ATP Locomotive Workshop (Bays 5 - 15) (SSD-8449-Mod-4)
Request for Additional Information

I refer to the modification application for alterations to the internal design and layout of Bays 5 – 15 of the Locomotive Workshop (SSD-8449-Mod-4).

Schedule 1 – Additional information

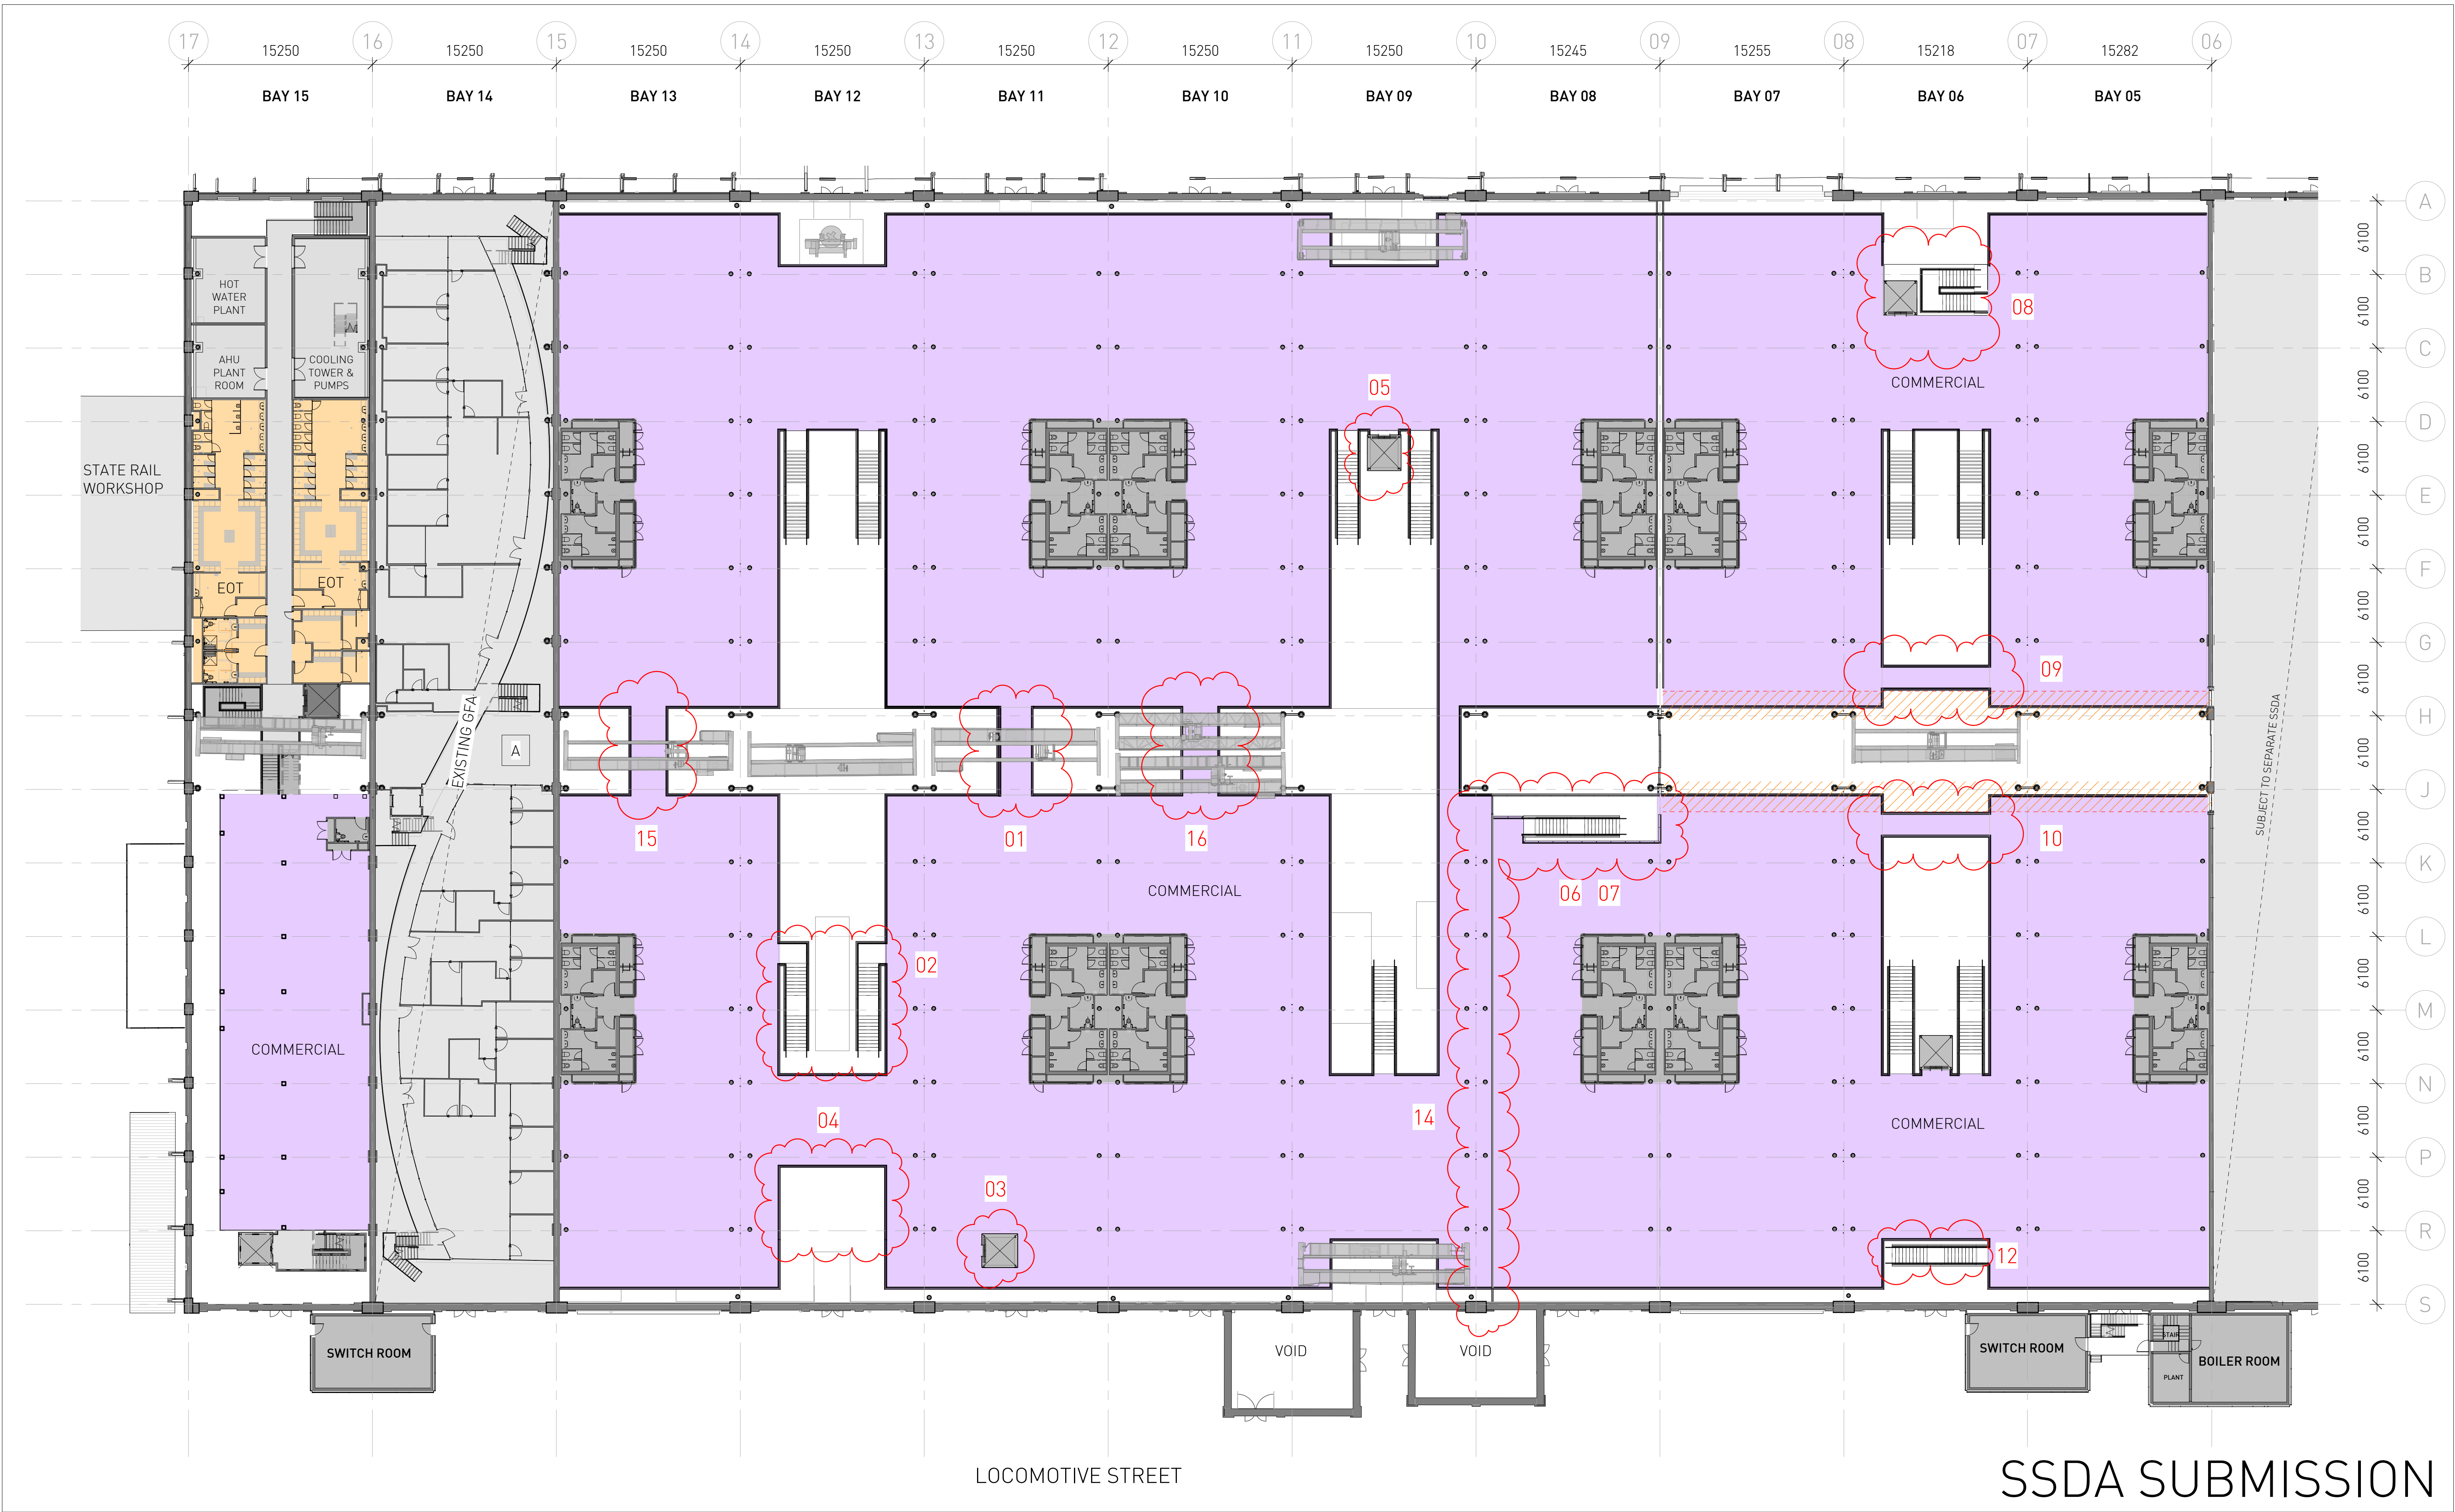
- For item 7:
 - clarify the balustrade proposed to be converted to full height glazing is the wall between gridline 9 and 10 that faces the central spine

- provide further detail on the reason for the wall, given the previous floor plan placed this wall on gridline 9 and a balustrade was provided.
- Provide further detail of the BCA and fire engineering requirements that necessitate the additional link bridges (items 1, 9 and 10) and provide a visual image of an additional link bridge.

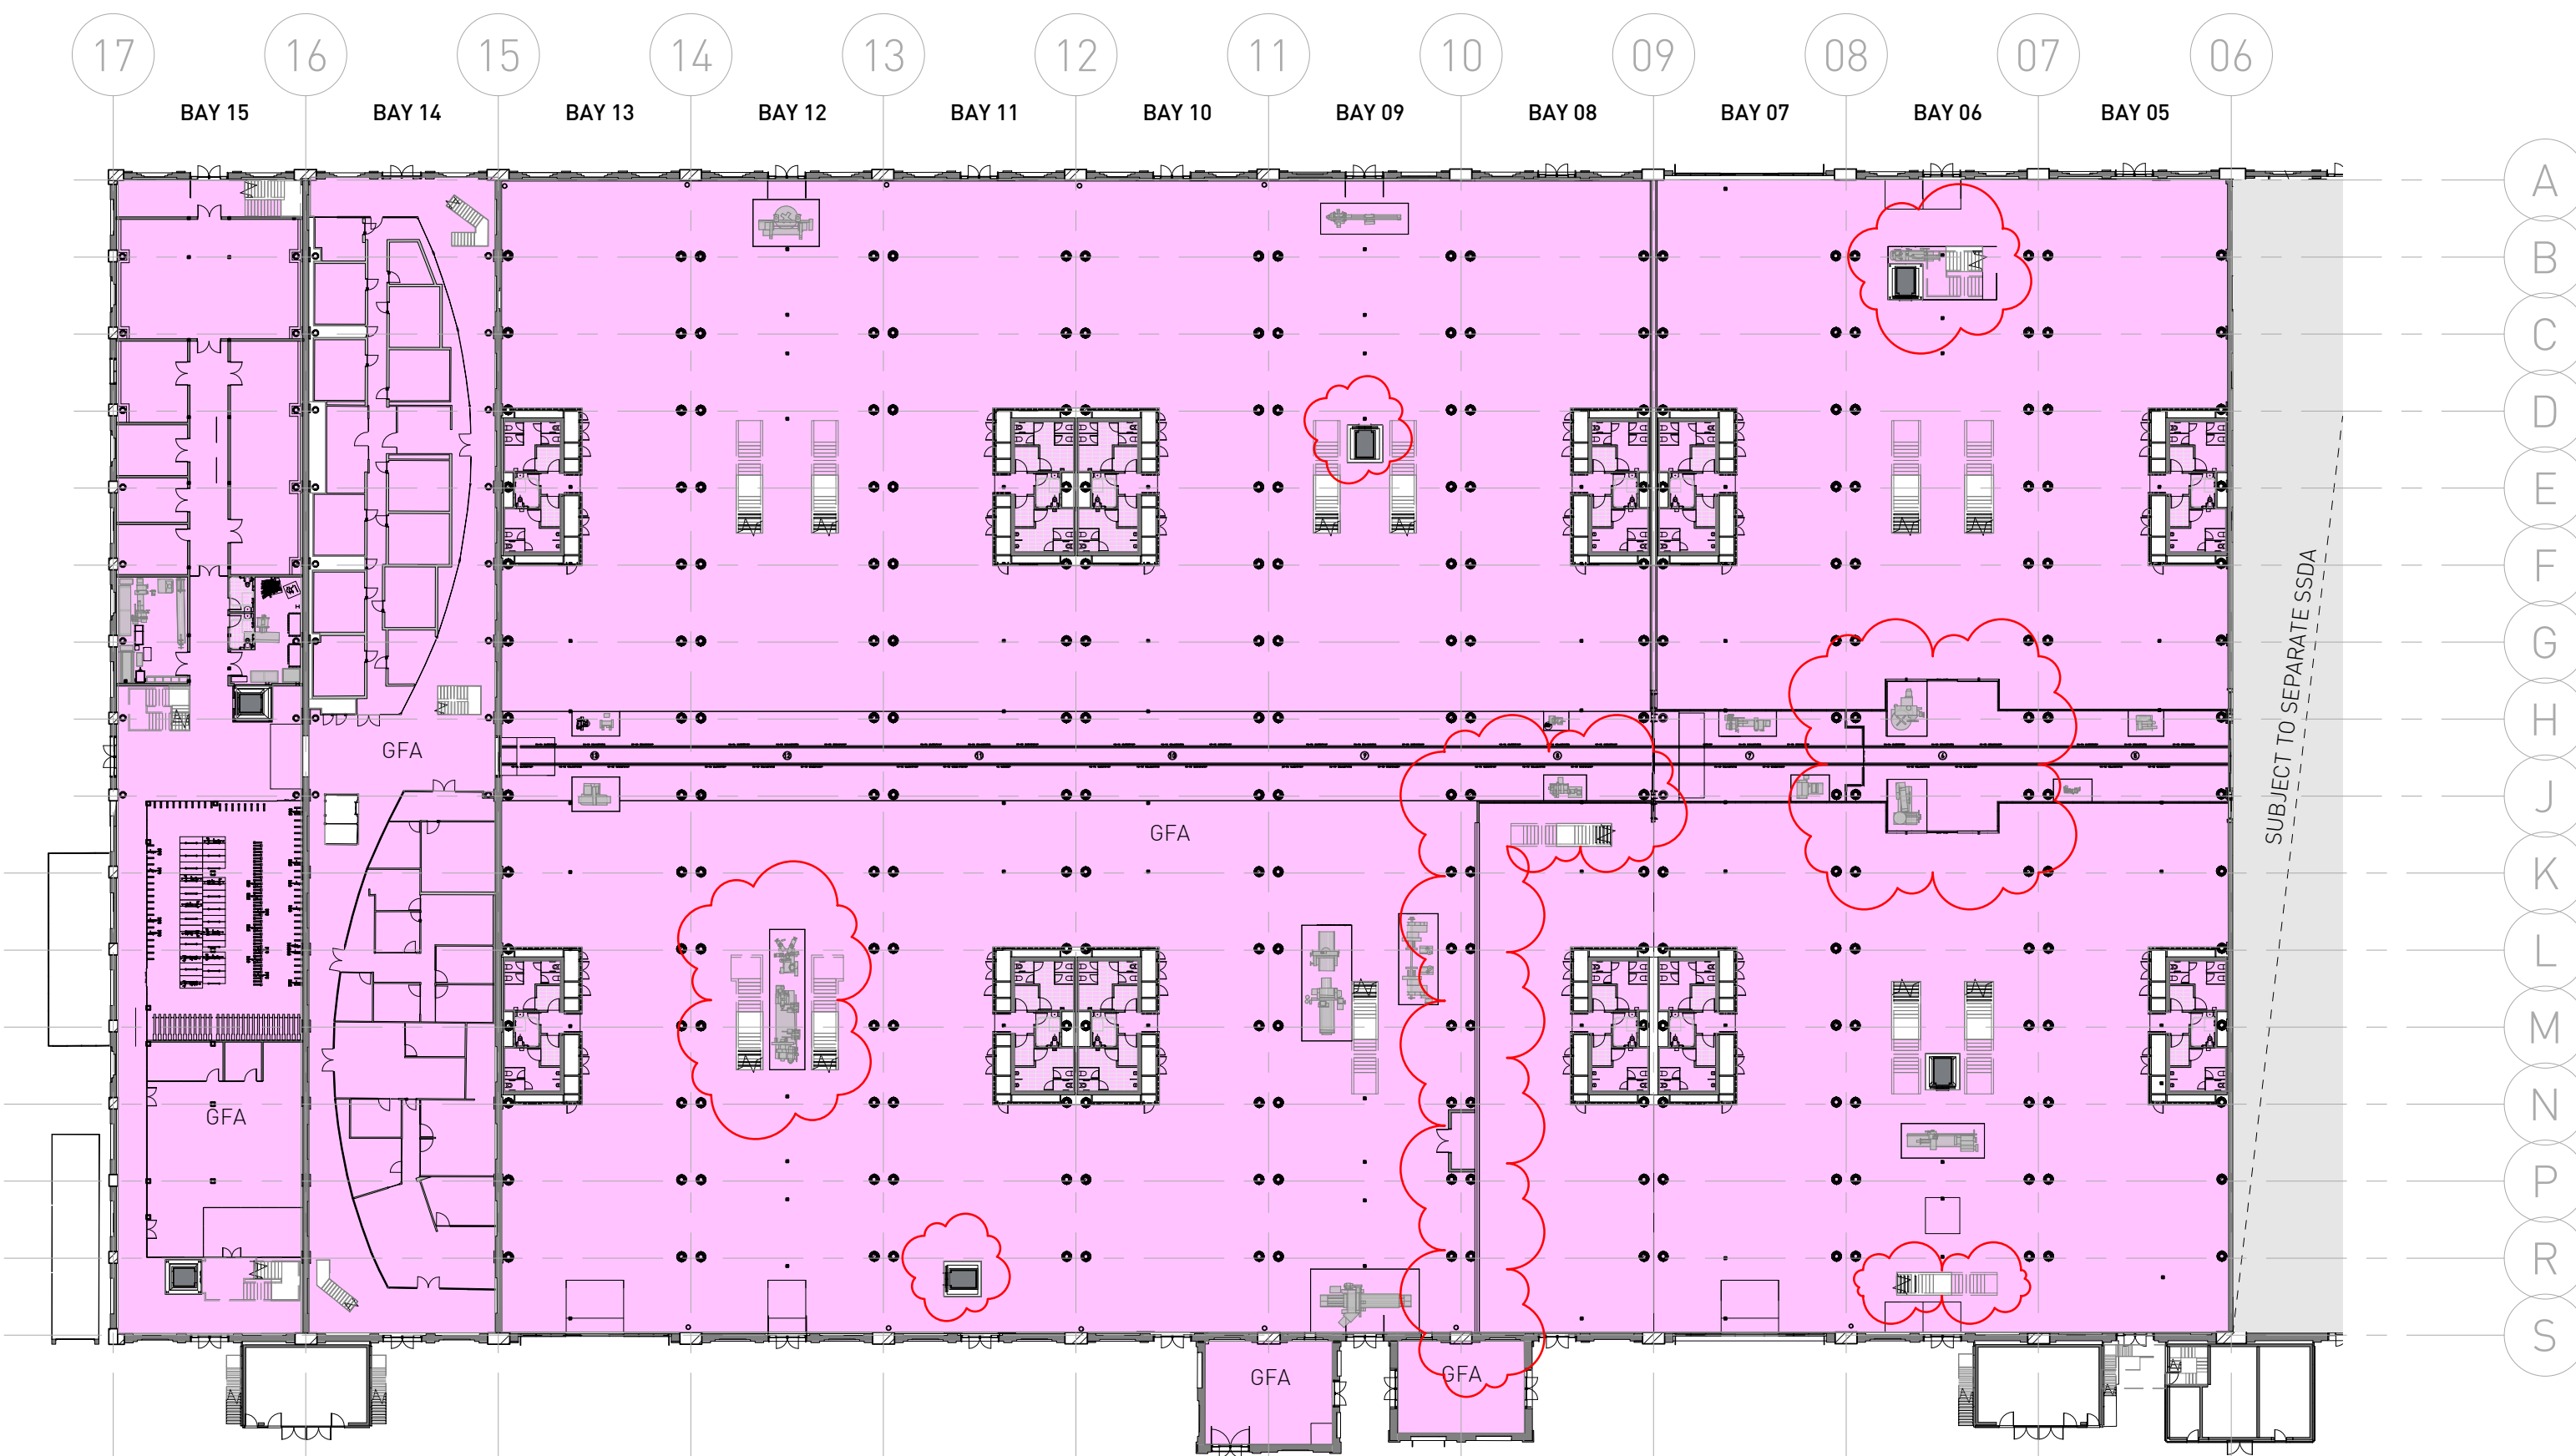
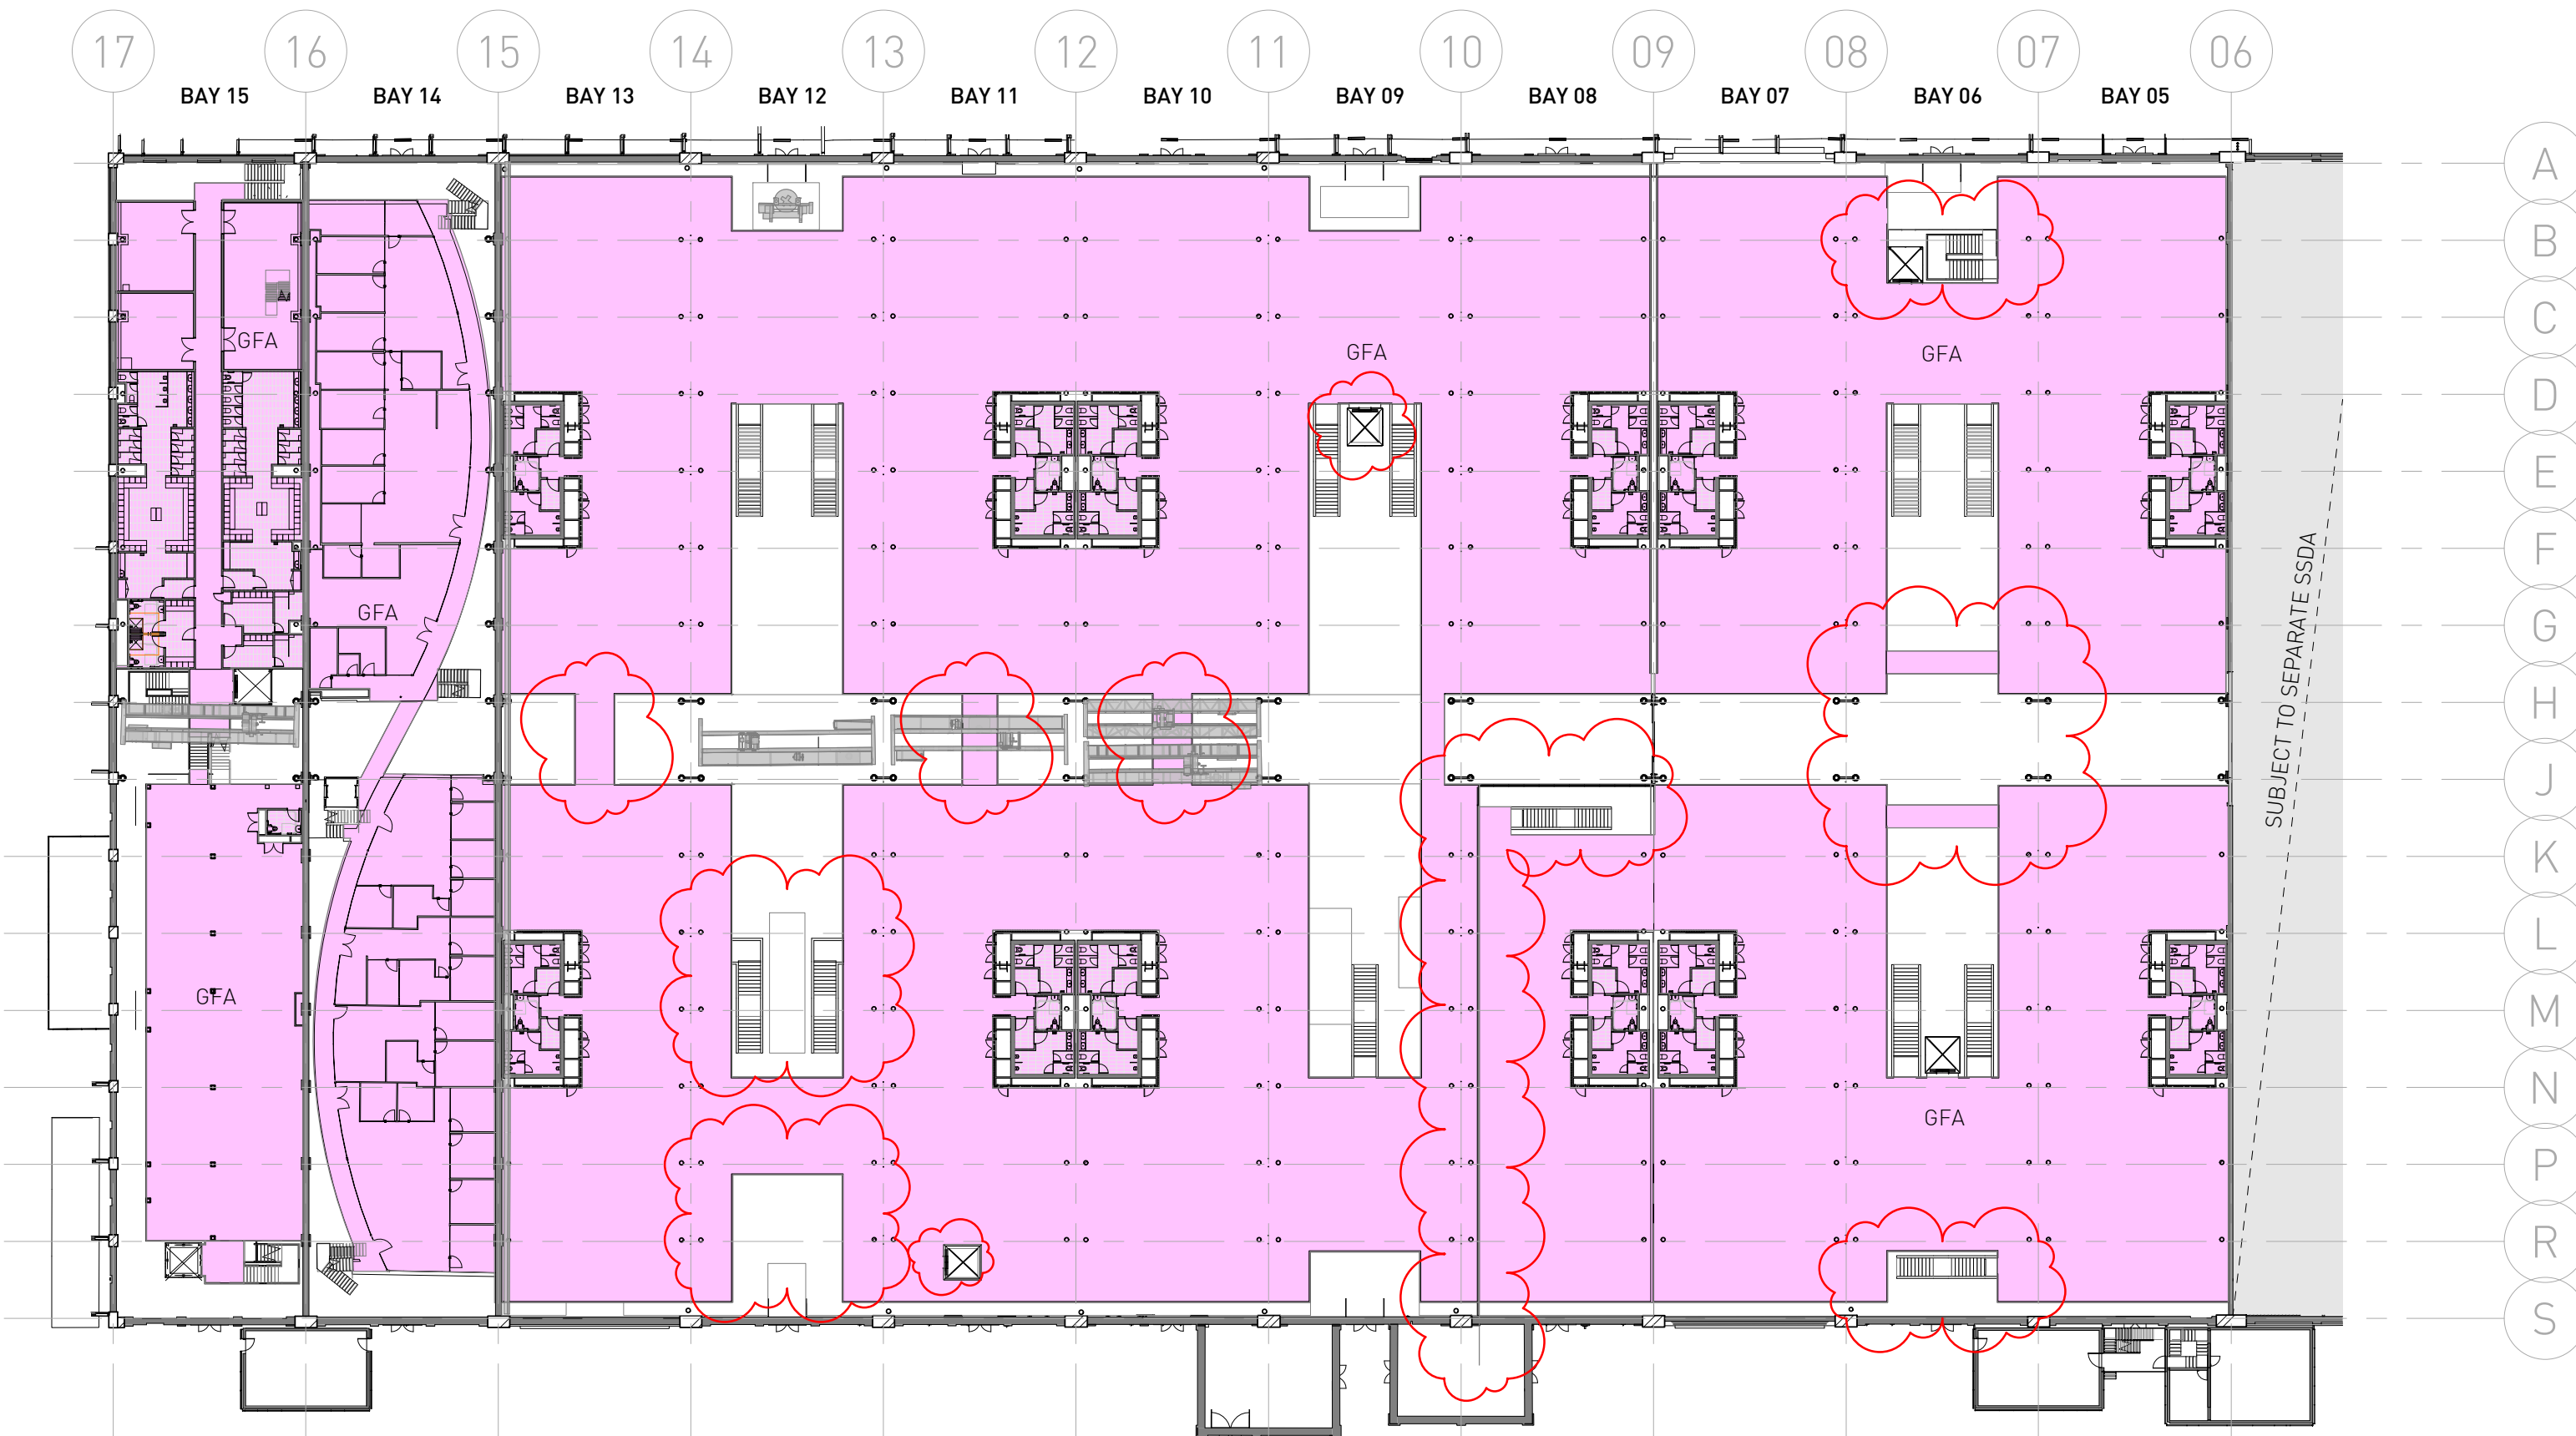
- Identify the material proposed for the intertenancy wall that is proposed to be moved from gridline 9 to 10 (item 14).
- Confirm the GFA calculation changes from approved plan, SA-AR-DWG-BB-B4-0250 Rev T, to the submitted plan, SA-AR-DWG-BB-B4-0250 Rev U.
